Jeanie Bourke <jmb@portlandmaine.gov>

224 Shore Rd, Cushings Island, Permit 2017-01888 (amendment)

1 SITE PLAN  
1" = 20'-0"

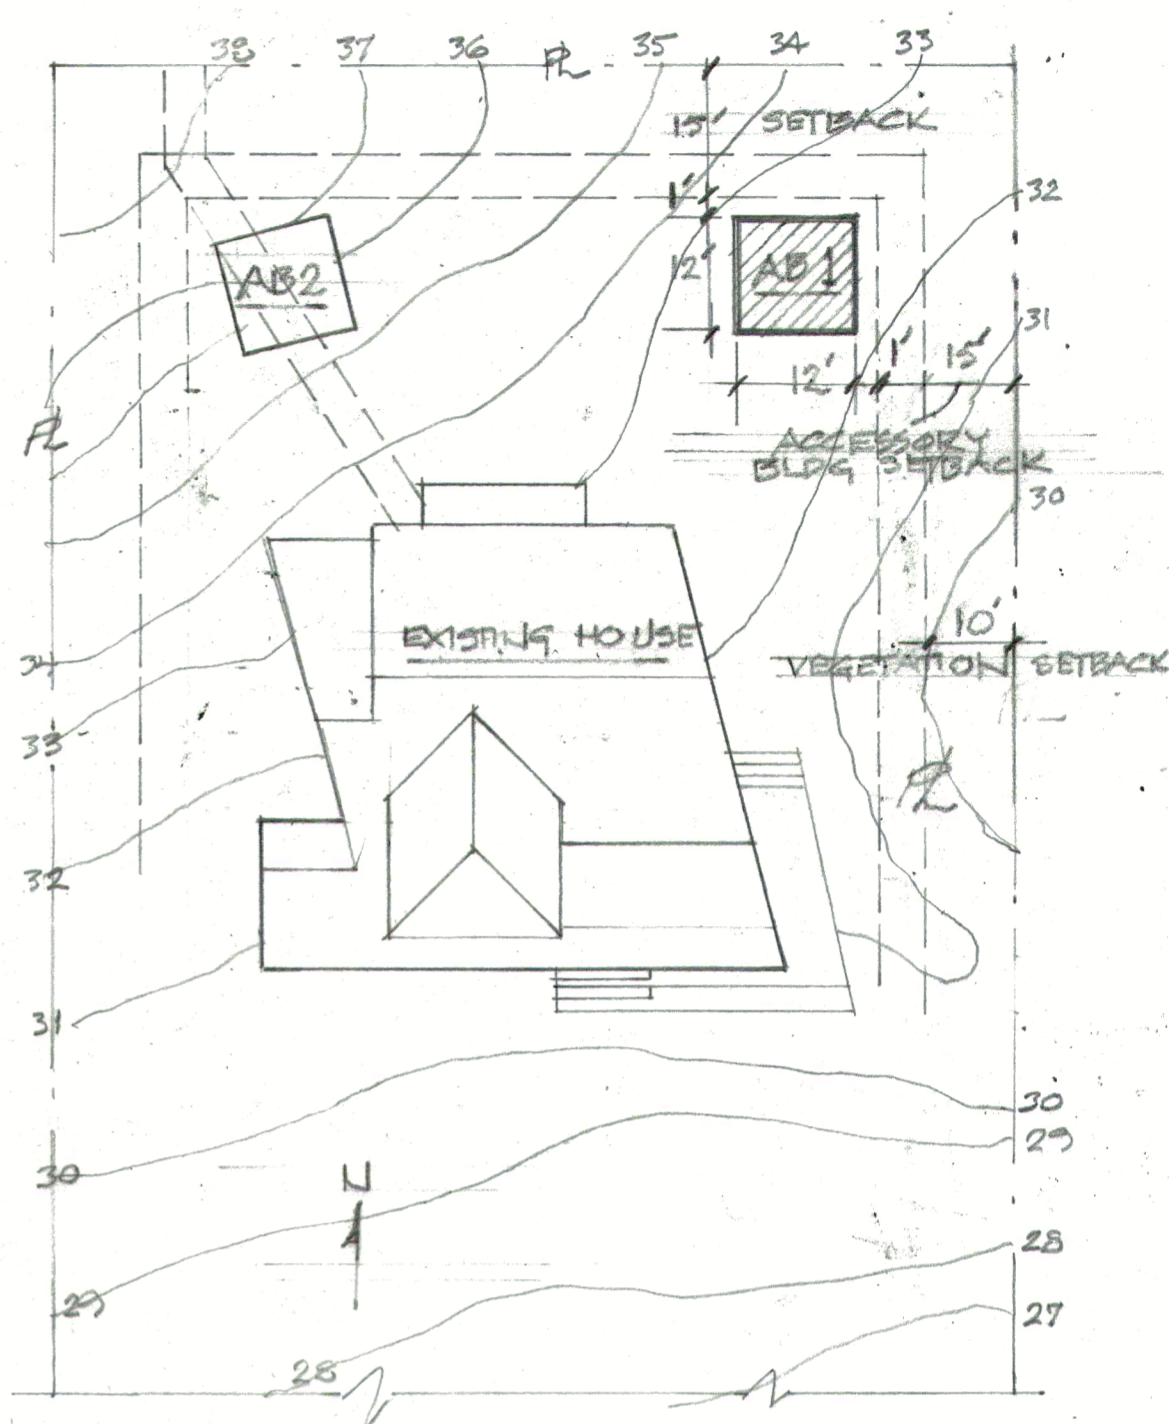
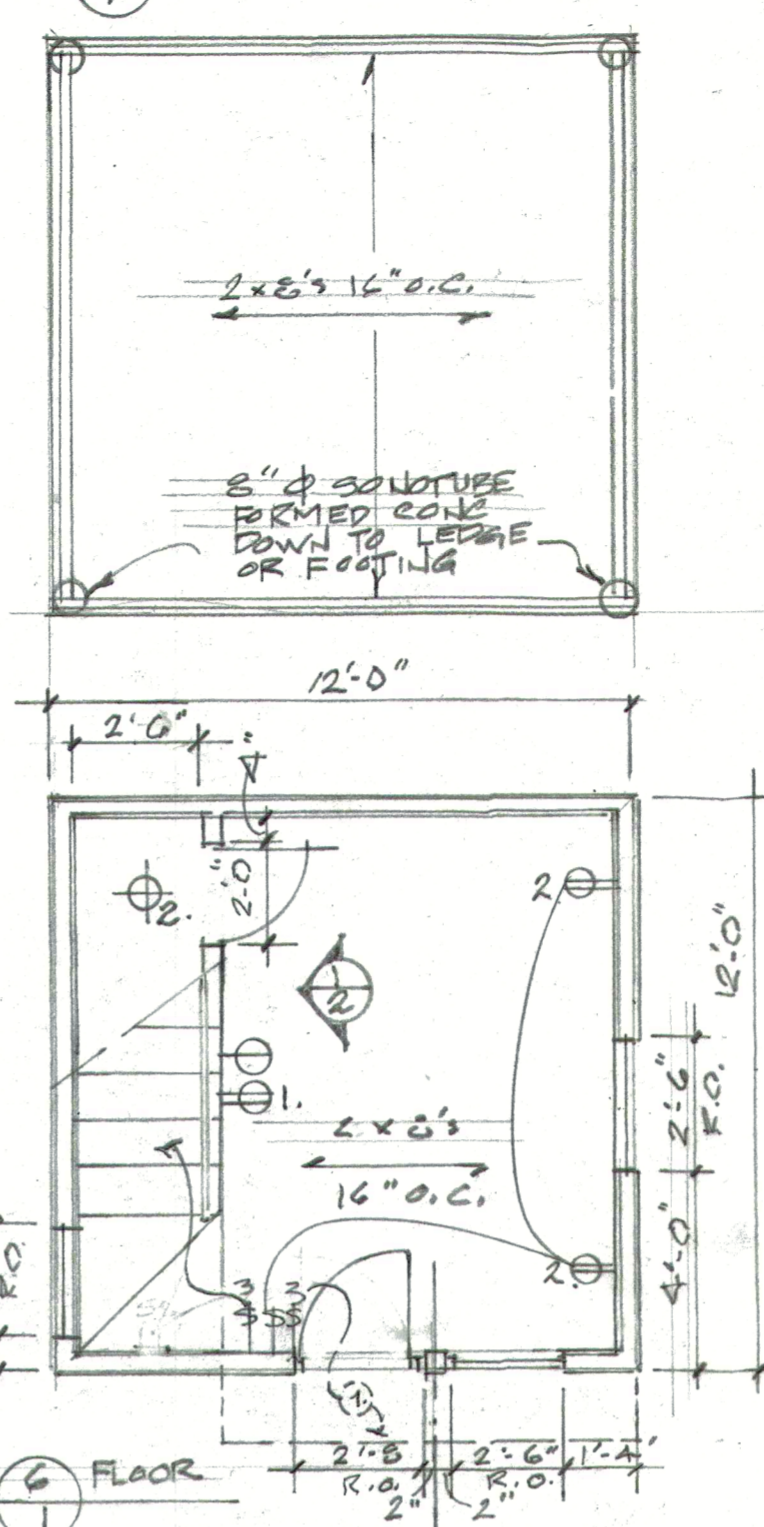
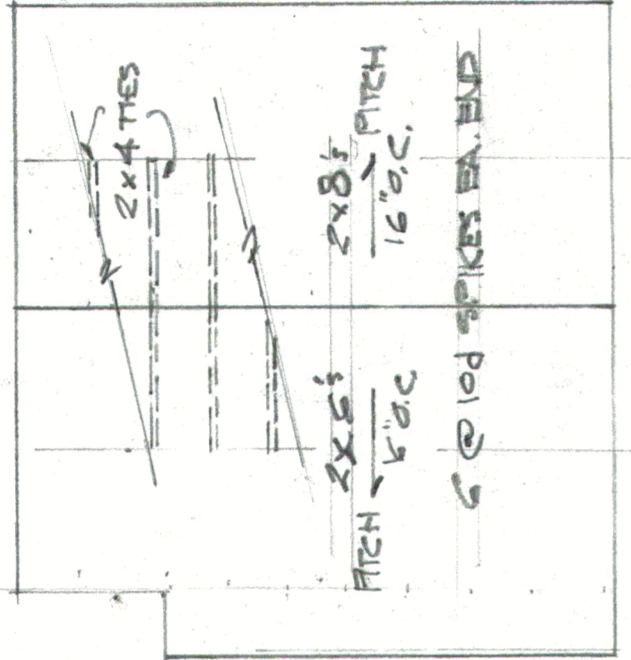
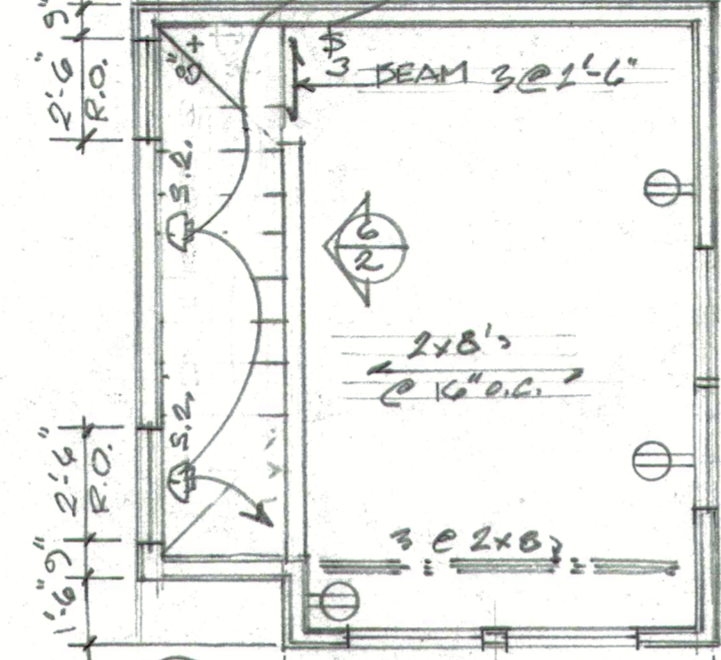
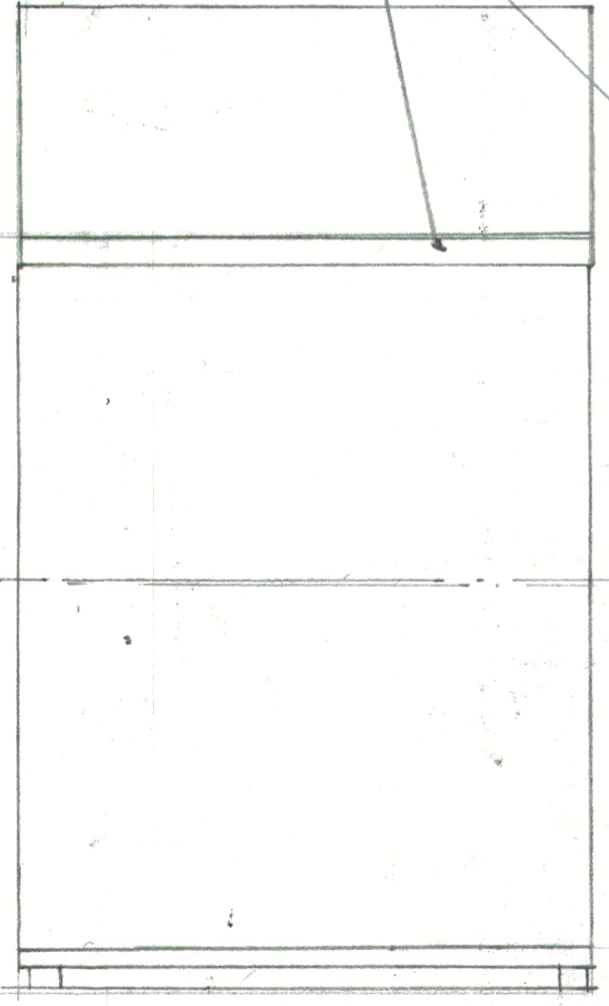
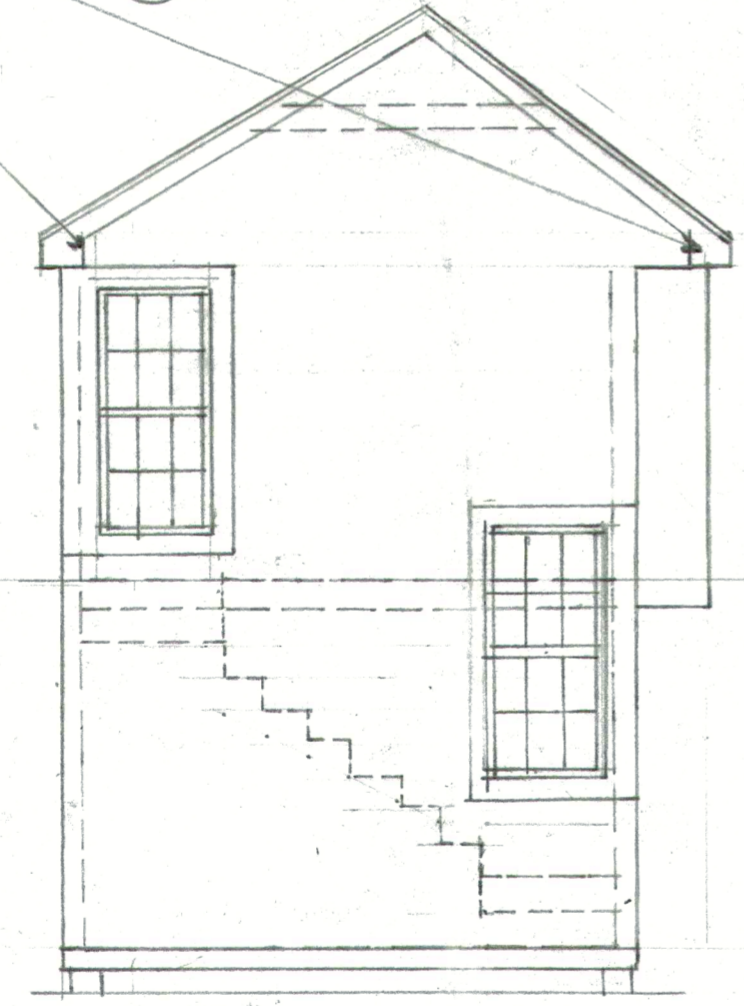
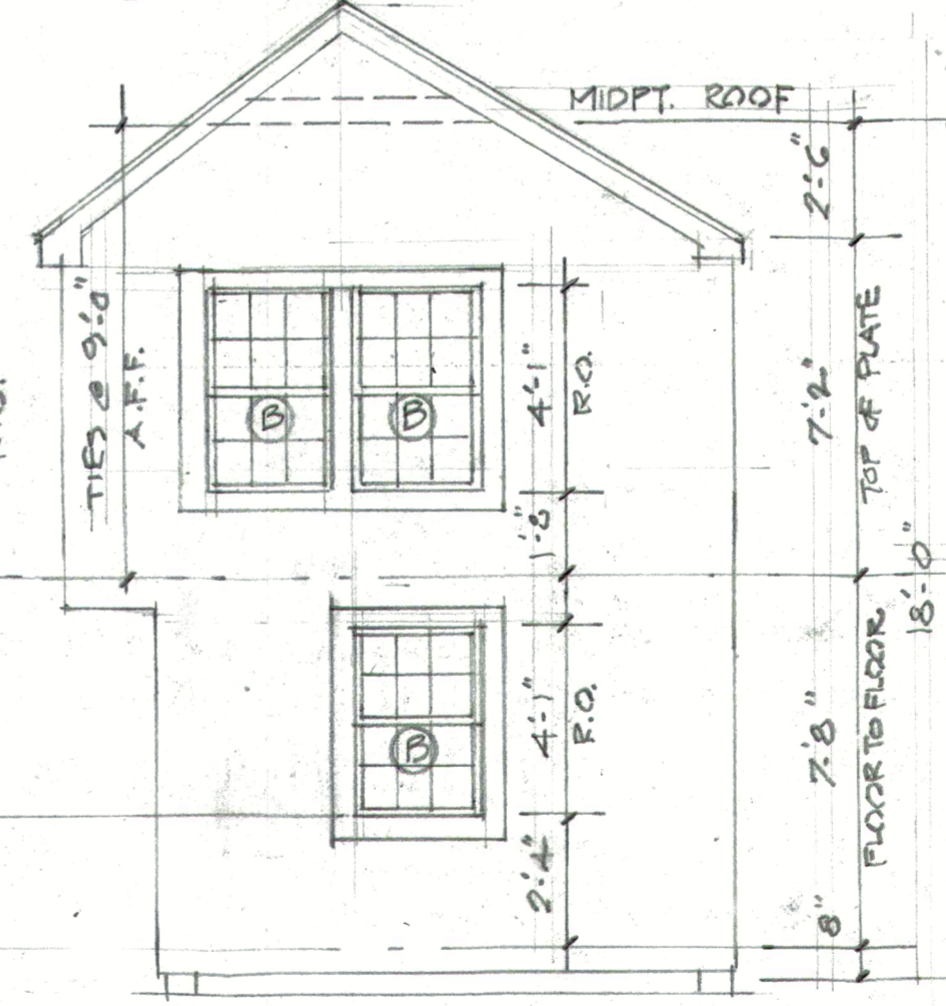
1. We have surveyed the 144 sf footprint for the accessory building, and have learned that no heavy concrete foundations and footings are needed. Bedrock is just below the surface. Four concrete sonotube posts at the corners will suffice, with a conventionally framed wood structure above.

2. The permitted function of the building is storage. ility No change to that. If the budget permits we'd like to have the possibility for a simple framed storage attic or loft at 8'-0" above the floor. (Per Jeannie's and my discussions earlier about the loft in the addition, which is now deleted) we'd like to access this storage level with a disappearing ladder like that commonly found in houses to access attics. The framing of the house is not dependent on the attic floor although it would be useful for bracing.

3. The attic would not be a habitable area per code, storage only.

All that I need to be able to approve the amendment (2017-01888) for zoning is to have AB2 removed from any of the plans for the permit that include the site plan. The proposed addition to the main house meets the dimensional requirements as does the footprint for AB1. The use of AB1 is for storage.

I just checked in with Jeanie but she is in the middle of reviewing another project and did not have time to look at your email at this time. It sounds like you are proposing changes to AB1. If there are any changes to what Jeanie reviewed originally under Permit 2015- 00606, I would suggest that you submit brand new plans for exactly what you want to build for AB1. This would make it a cleaner, more efficient review for Jeanie. Also, you need to submit plans for AB1 for what is being built right now. Either the loft is part of the plan or it isn't.

As long as the AB1 still meets the height off grade a storage loft is acceptable accessed by a typical pull down stair for an attic space. As Ann stated, these changes should be included in the plans for this amendment.

I think we are all set: the building does meet the height off grade, and the storage loft is accessed by the pull down stair. The AB1 is all on one sheet this time, and I will finish it by the end of the day today and get it off to you.
